## **DEPARTMENT OF PUBLIC WORKS**

**TO:** All Staff  
**FROM:** Public Works Planning Review Team  
**DATE:** September 2, 2020  
**SUBJECT:** SPF-20-00003 JD's Happy Heights Final Short Plat

J.D.'S HAPPY HEIGHTS SHORT PLAT

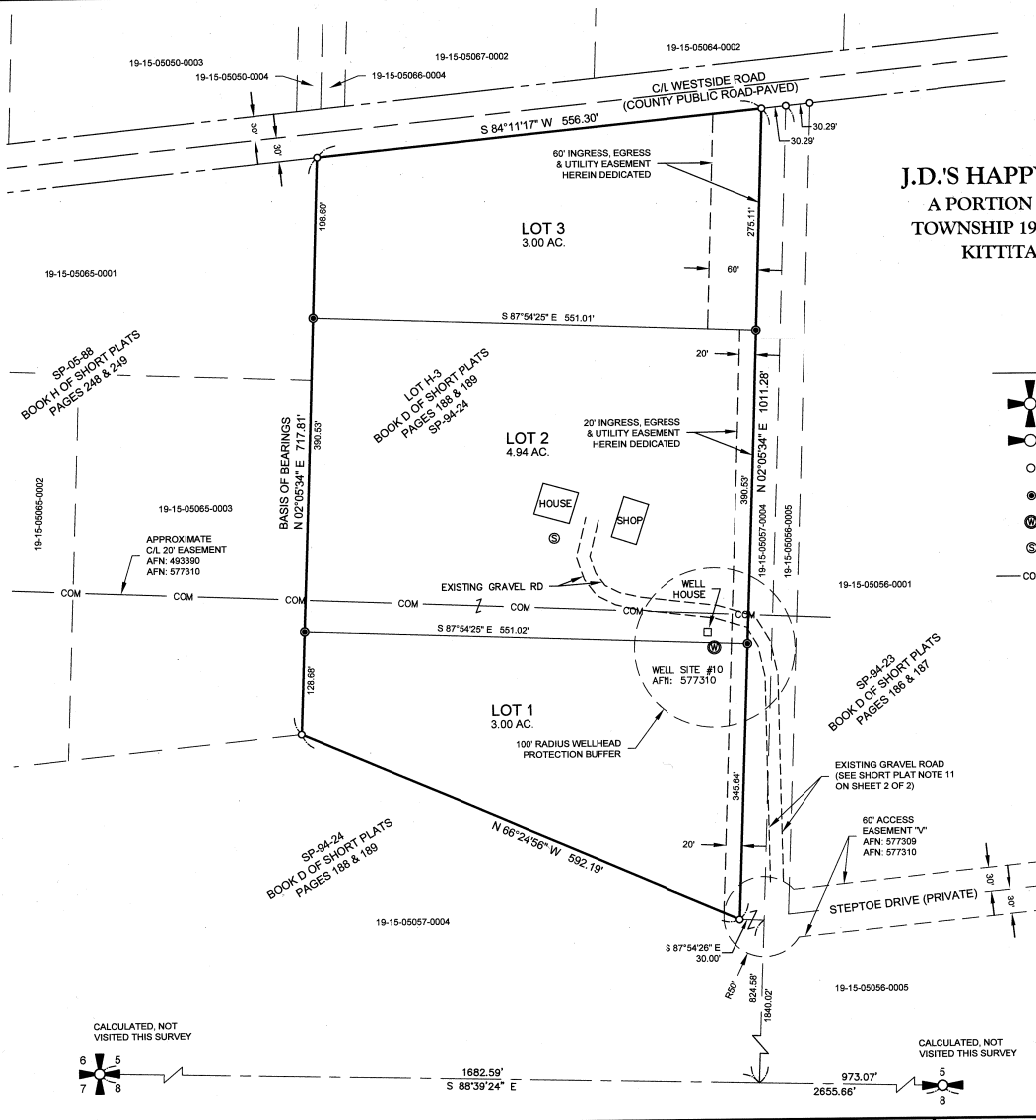
- A. Public works recognizes that the driveway to Lot XX is the historically utilized access, to said lot. As it does cross multiple parcels to get there, a note identifying the driveway as prescriptive easement would be a benefit to future landowners.
